Ribchester Parish Council

PLANNING APPLICATION No: 3/10/0660

Application: Proposed erection of a general purpose agricultural building, hardstanding and new septic tank.

At: MOOR HOUSE FARM, CLITHEROE ROAD, KNOWLE GREEN

Drawing Title
PROPOSED ANCILLARY BUILDING

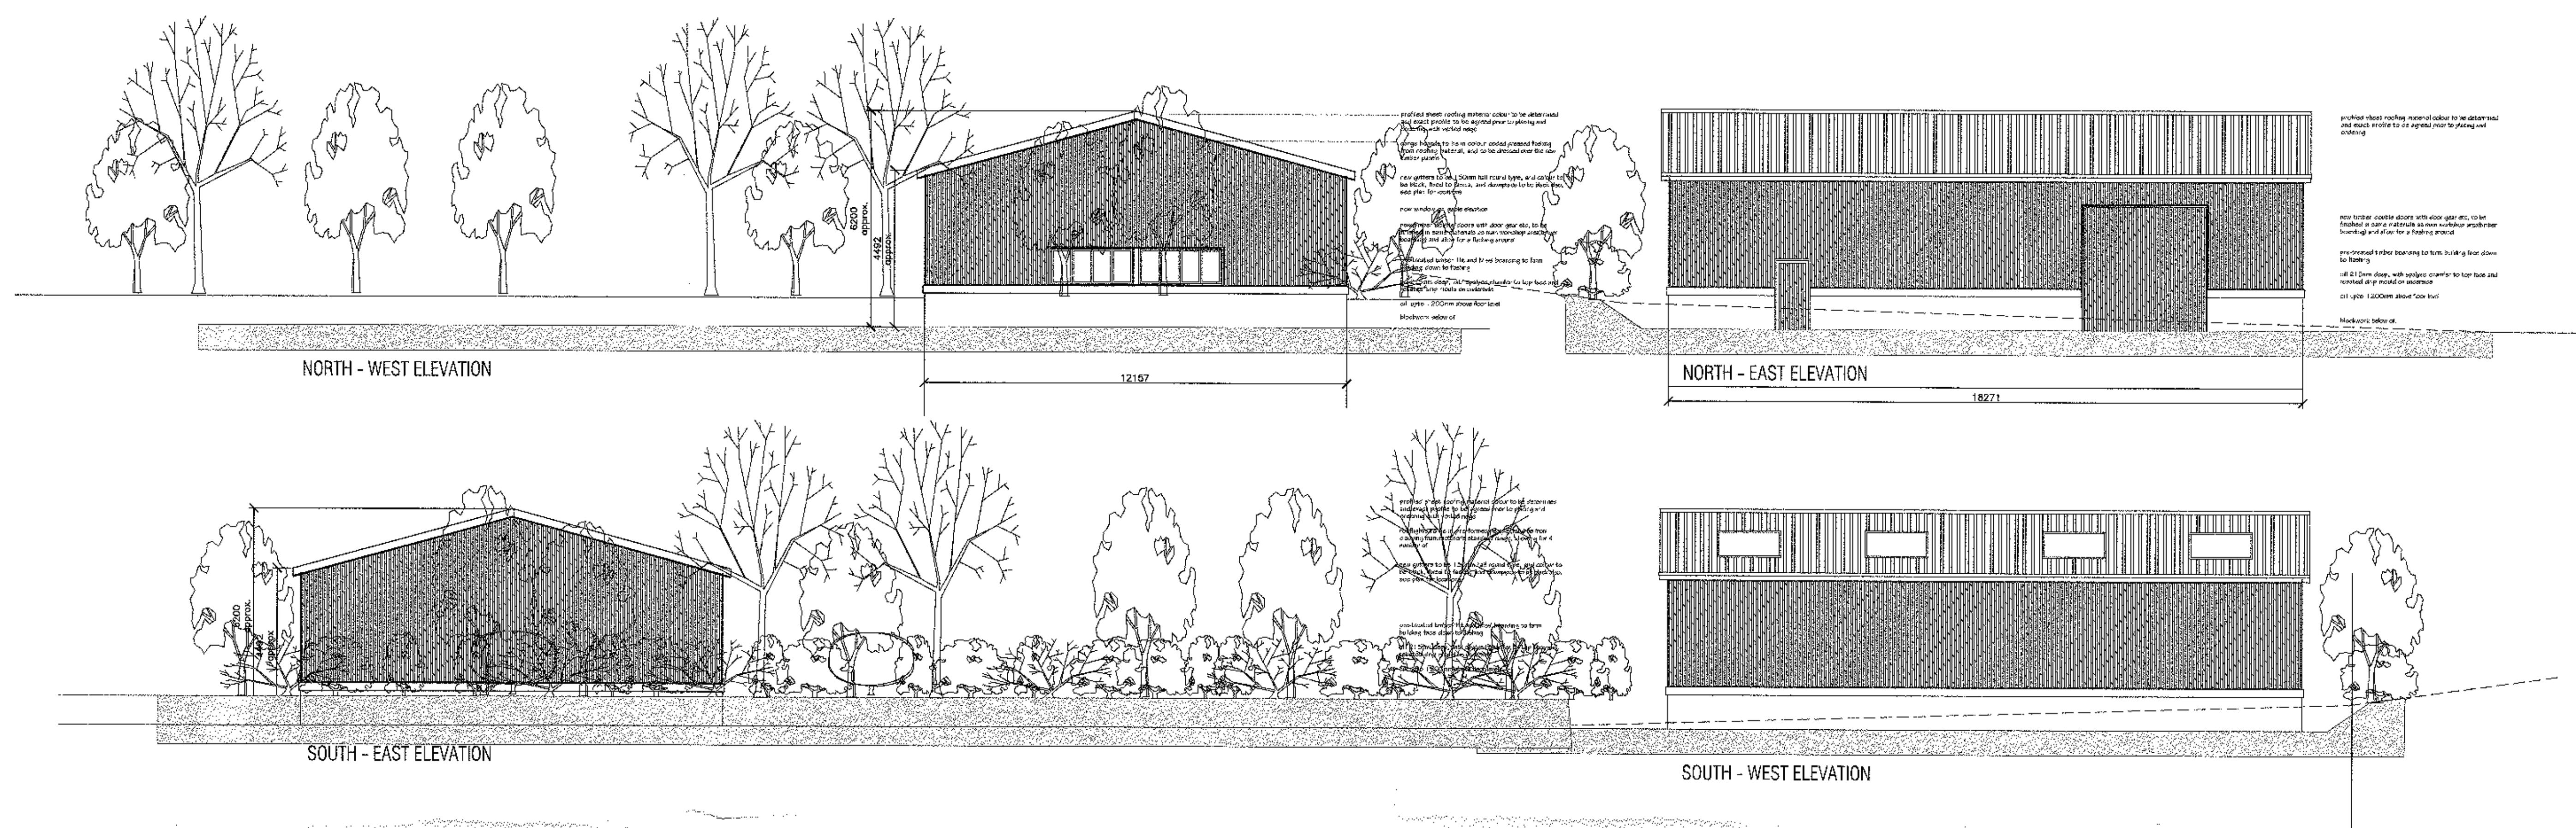
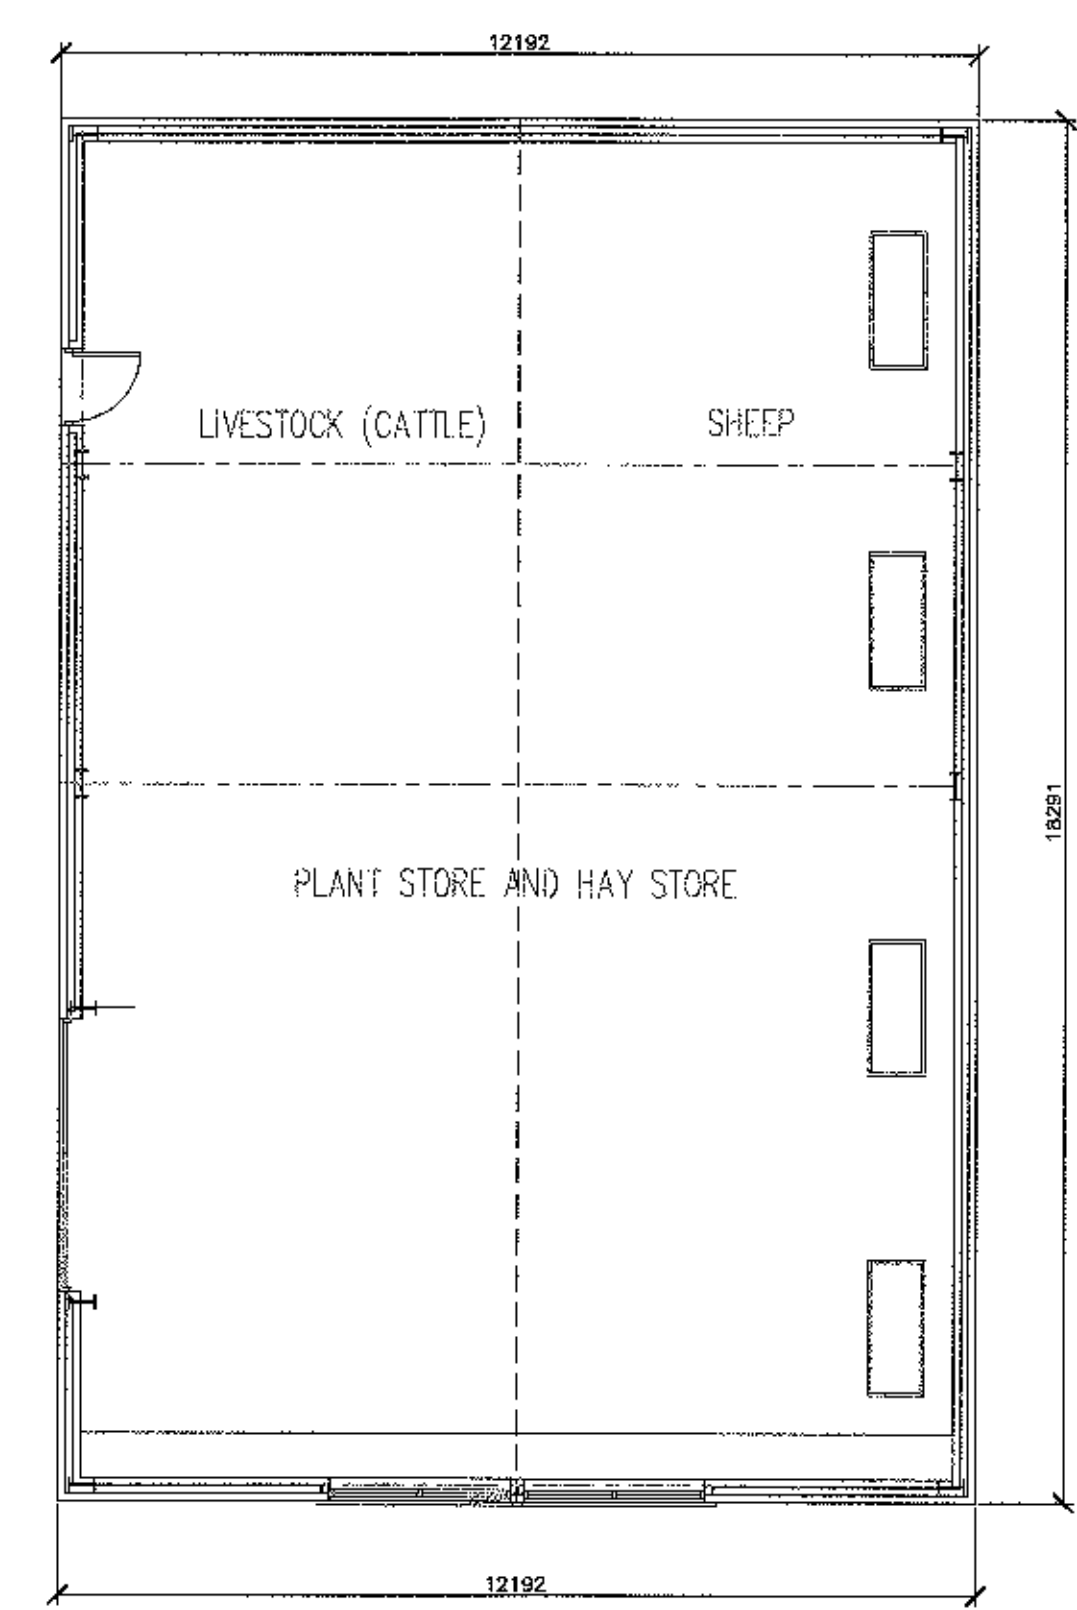
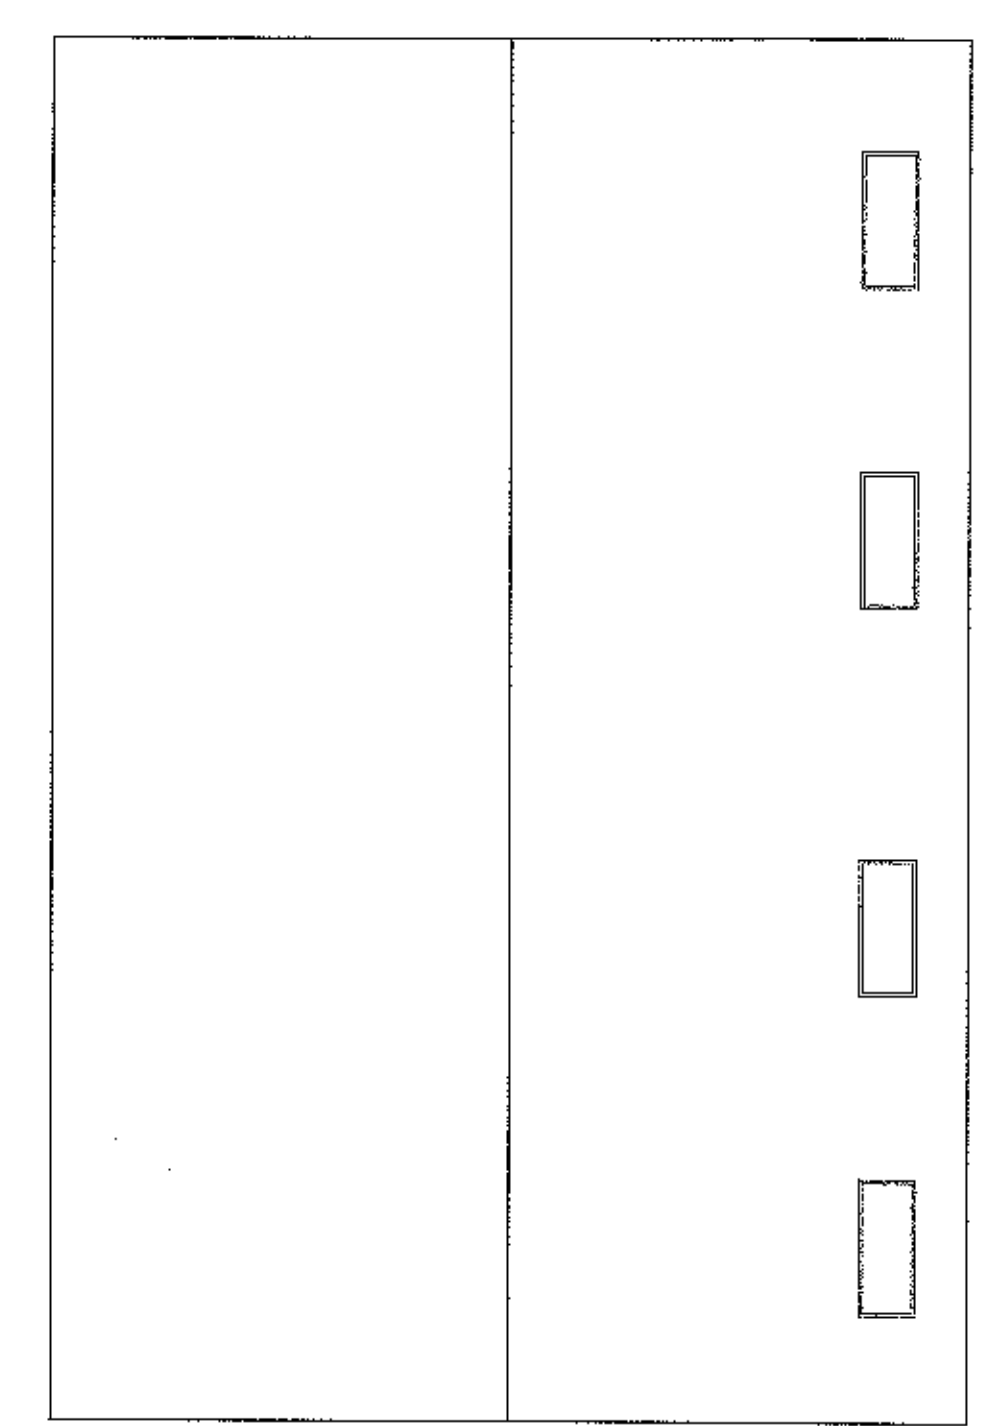
There are two concerns to be addressed. Firstly the rejection of the earlier application was centered on three policies; G1 (design), G5 (the barn would lie outside the main settlement and ENV3 (proximity to the AONB which requires that developments be in keeping with the character of the landscape area). While some changes have been made to the design the proposed construction is pretty much as the earlier application.

Our second concern is that the application comes with little in the way of detail. For example there is mention of a concrete yard but no dimensions are given. It would be used for beef cattle during the winter but the handling of slurry remains open. Is a tank to be added later? The application includes the heading 'septic tank' but no details are provided of size, volume, source of input and where the partially purified water that emerges is to go. What then happens in a flash flood situation? Will solids then become part of the outgoing flow from the tank?
